## Appeal Decision

**Appeal Ref: APP/R5510/W/24/3357880**

**17 Broadwood Avenue, Hillingdon, Ruislip HA4 7XS**

- The application sought planning permission for new build replacement dwelling house without complying with a condition attached to planning permission Ref 14578/APP/2022/1838, dated 16 September 2022.

RETROSPECTIVE PLANNING 17 Broadwood Avenue, Ruilisp. HA4 7XS			
PROPOSED PLANS			
Scale:	1:100 @ A3	MAR 2024	Dwg. 21_142_P2

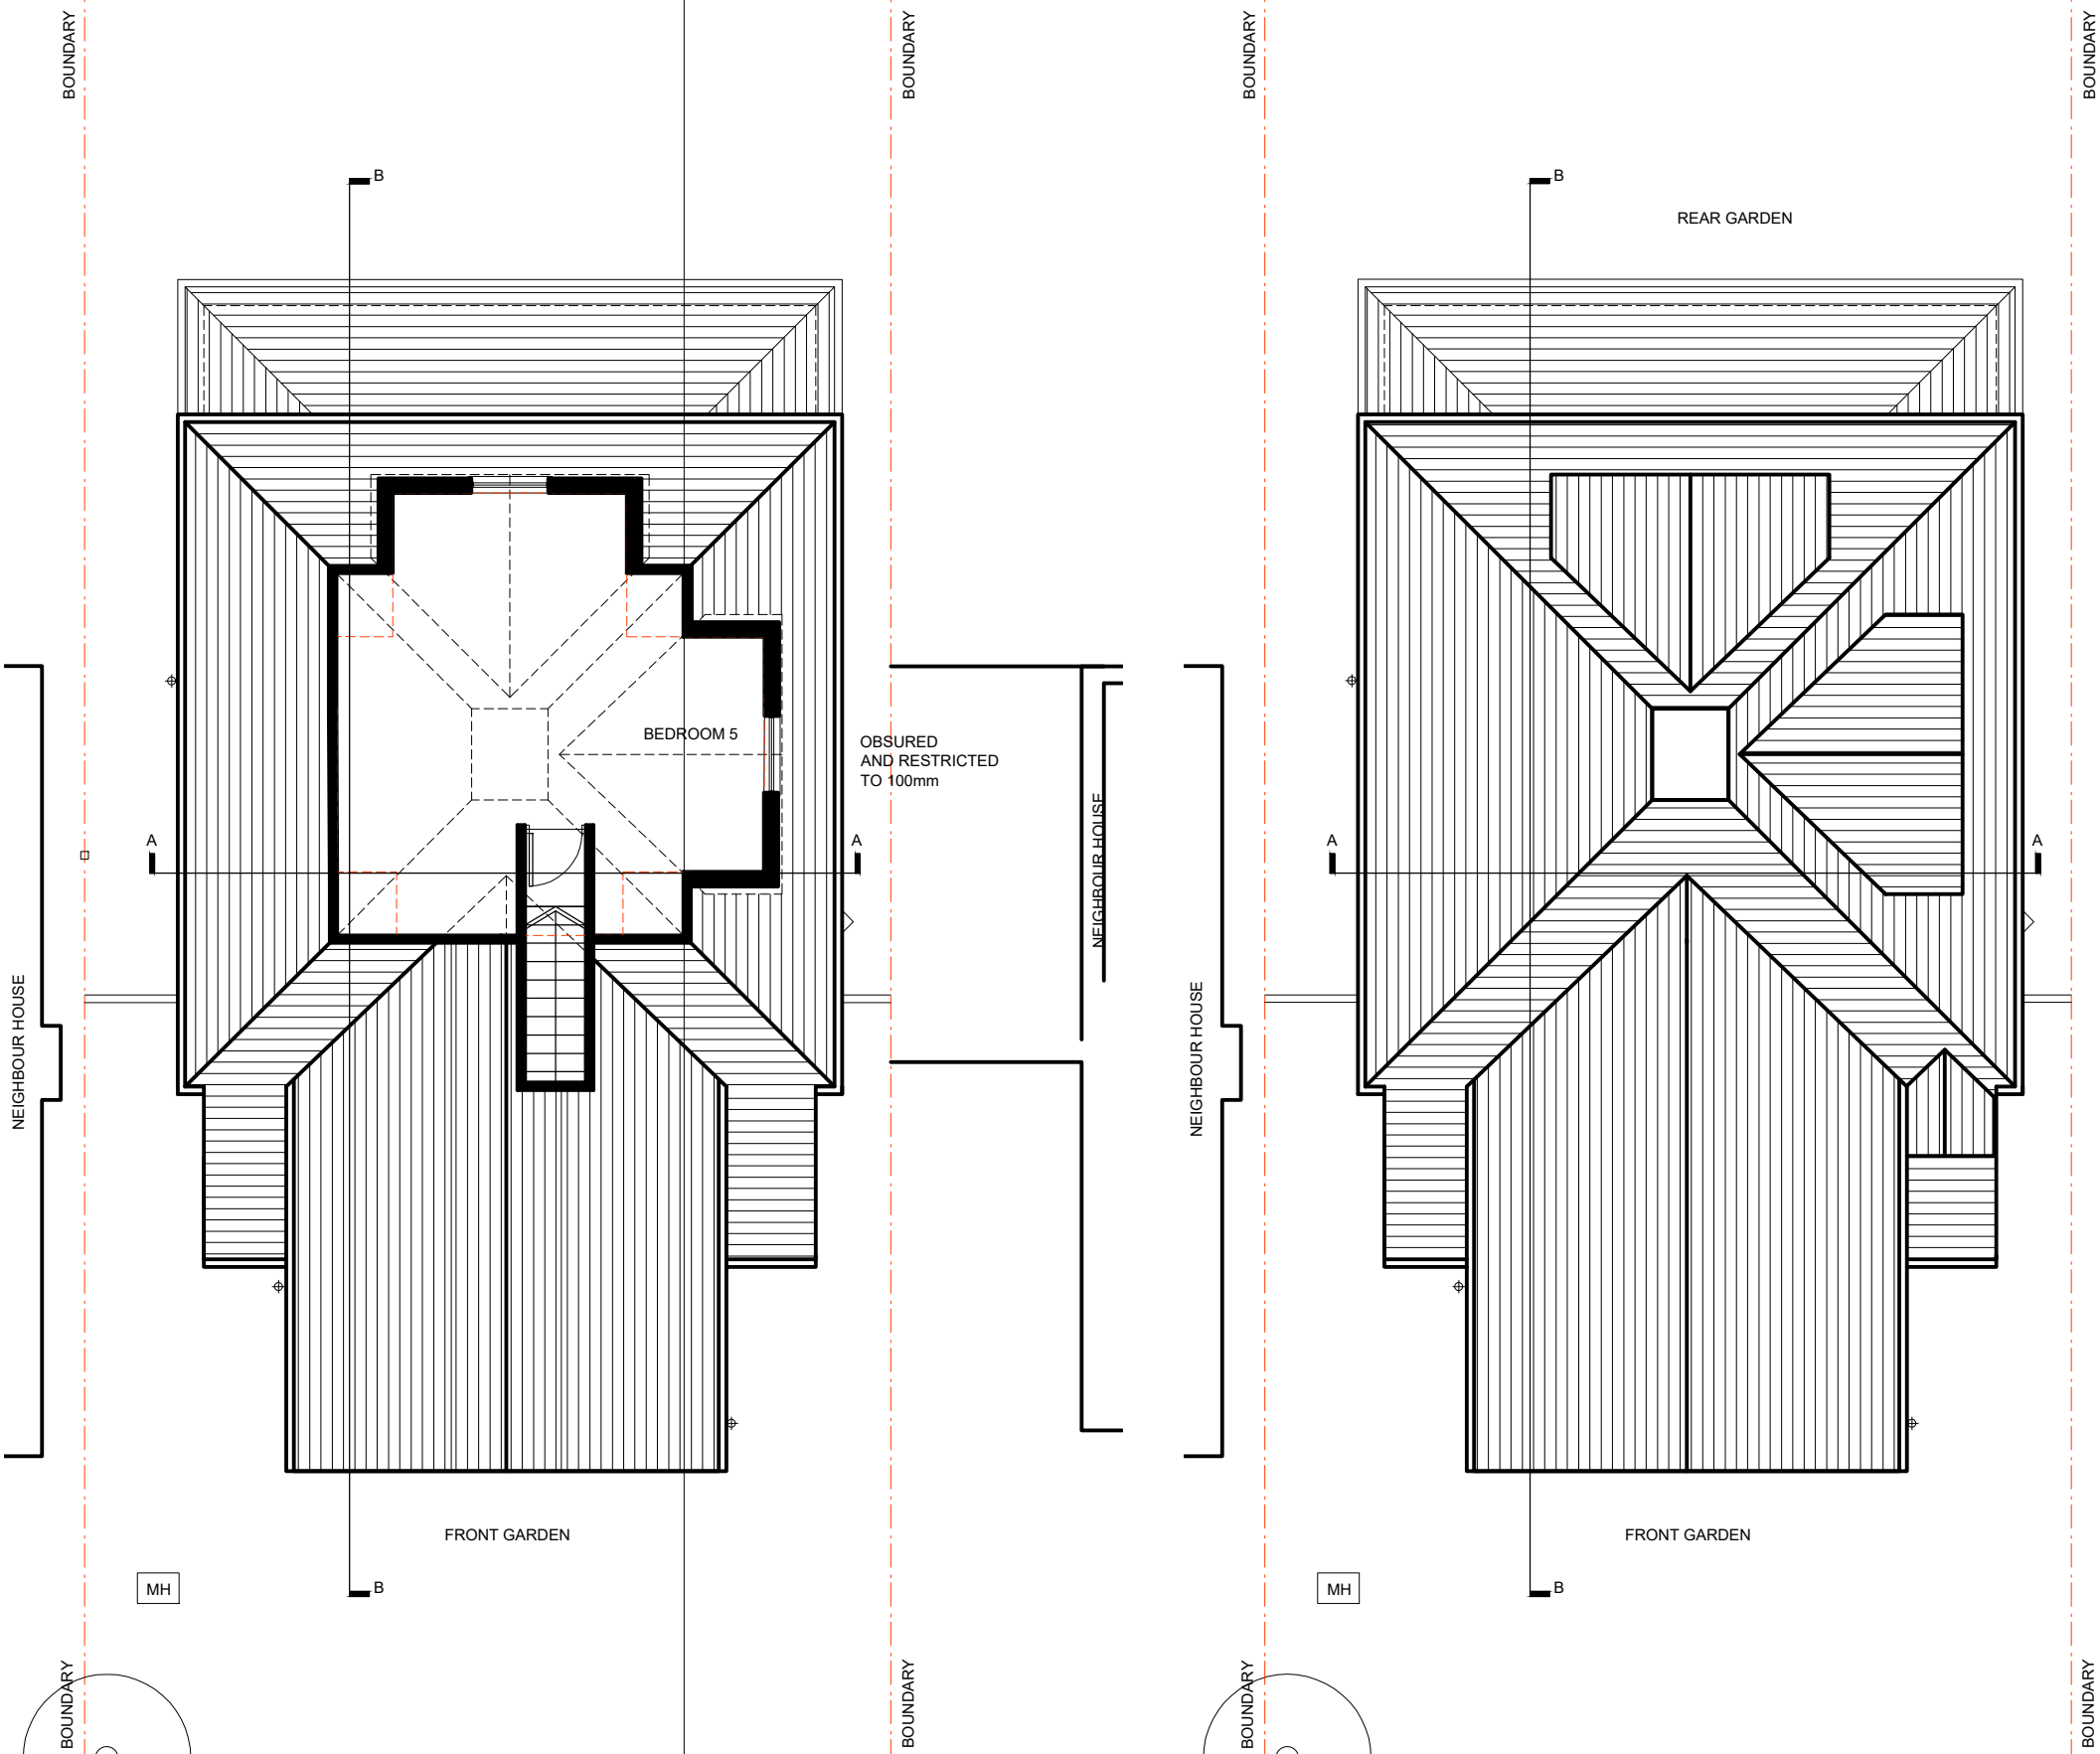
5. The appeal scheme essentially seeks to erect a side dormer on the west roof slope rather than the east; to install a window at 2<sup>nd</sup> floor level in the front gable projection; to erect a front dormer at 1<sup>st</sup> floor level; to insert an additional window at 1<sup>st</sup> floor level in the west elevation; to position the main entrance door centrally within the projecting bay at ground floor level; and to insert a window to the side of the entrance door. To my mind, the combined effects of these elements need not be considered if any of them are unacceptable within themselves. I will therefore address the merits of each individually to begin with.

6. The proposed western roof dormer is much the same size and design as the one approved on the eastern side. It would not add any greater bulk, nor unbalance the form of the roof to any greater extent. It is not out of character in the street given the number of houses that have similar dormers on one side.

12. Given I have found each element of the appeal scheme acceptable in isolation, the in-combination effects must be considered; The west dormer, front dormer, and 2<sup>nd</sup> floor gable window would draw attention to the development of the uppermost level of the appeal site dwelling in a way which the approved scheme would not. This is because the front dormer is an additional projecting element, and the window is an additional glazed opening. Further prominence would result from the proximity of these elements to each other.
